PROJECT NO. 2020-004475  
Application No. SI-2021-00254

SUBMITTAL  
DESCRIPTION: Dental office for Pino Periodontics. This submittal includes the responses to the staff comments from the DRB hearing 4-14-21.

**RE: Pino Periodontics dental office development at 7413 Holly Ave NE.**

**RESPONSE TO STAFF COMMENTS:**

9 | hcp ramp detail A001 1/4"=1'-0"

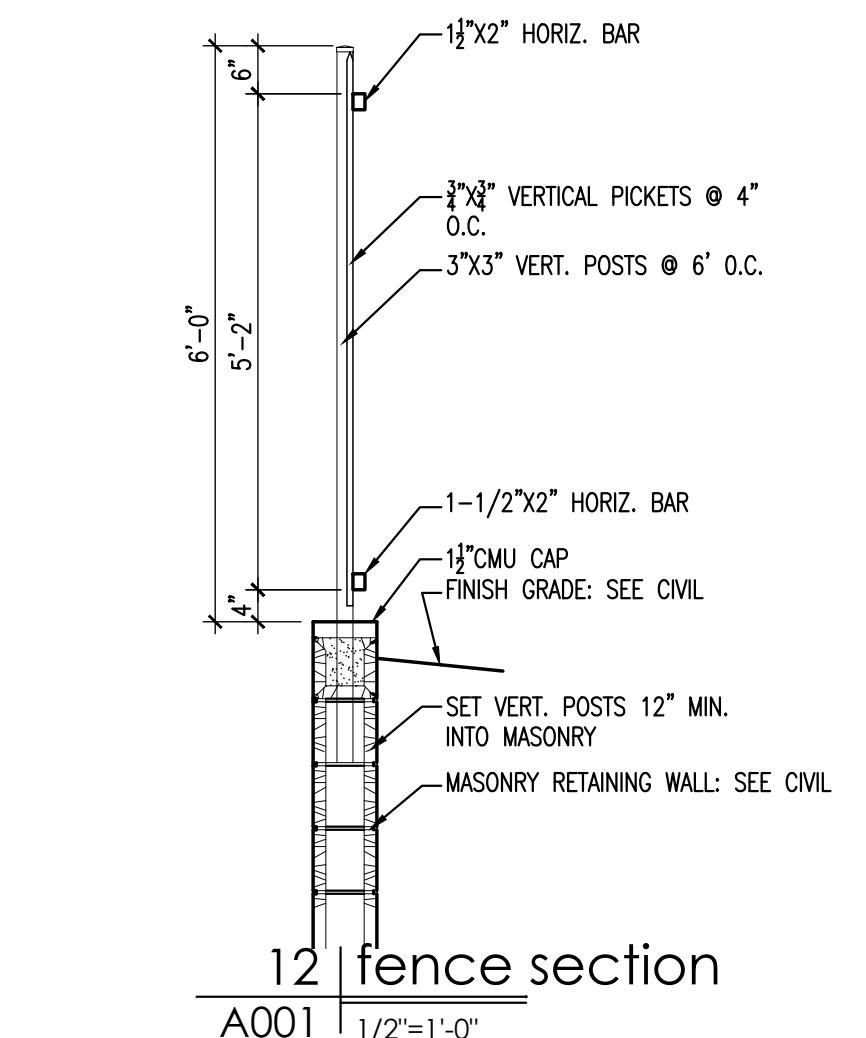
3. Provide a minimum 6-foot pathways from building to handicapped spaces and from right-of-way to building. (This comment now only applies to the ramps. The ramps shown should extend to the full width of the sidewalk to not only accommodate the 6-foot pathway but to avoid a tripping hazard and minimize conflict with the handicapped signage. Adjust walkways to leave space to make sure there is a clear ADA pathway from ramps as necessary.)

4. All curb ramps need a minimum of a 4-ft by 4-ft turning space at the top of the ramp. Provide additional sidewalk width and dimension or revise curb ramp type. (This comment now only applies to the ramp at the north side of the site. Also, there is not a detail for this ramp configuration. The reference calls out the curb.)

1. **Label on site curbs:** Keyed note 1 has been added to the site plan and indicated at on site curb and gutter locations.
2. **Bike rack requirements and clearances:** The bike rack has been relocated and redesigned per the requirements of the DPM.
3. **6' pathway to HCP parking spaces:** the hcp ramps have all been modified to comply with accessibility code.
4. **4x4 turning at top of ramp.** This applies to the ramp at the north side of the building which has been redesigned to match the other two ramps.
5. **Provide signed TIS form:** Signed TIS form is attached as part of this submittal.
6. **Add "8 standard" to the 2425-A reference.** This note has been added to street section.

8 | bike rack detail A001 1/2"=1'-0"

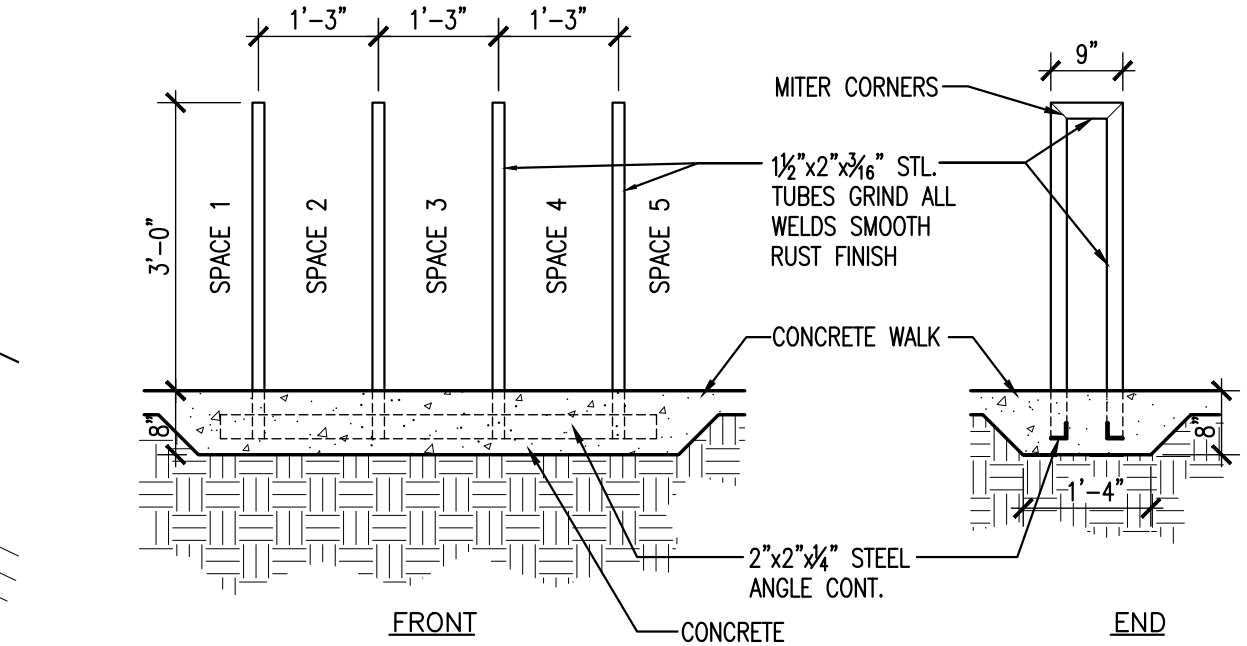
1. Label all on-site curb.
2. Match minimum required dimensions for bike rack per the IDO. Bike rack locations should be kept out of sidewalk to avoid obstruction of the pathway. (Bicycle spaces are 6 feet long and 2 feet wide. Rack dimensions are minimum 30" tall by 18" wide.)
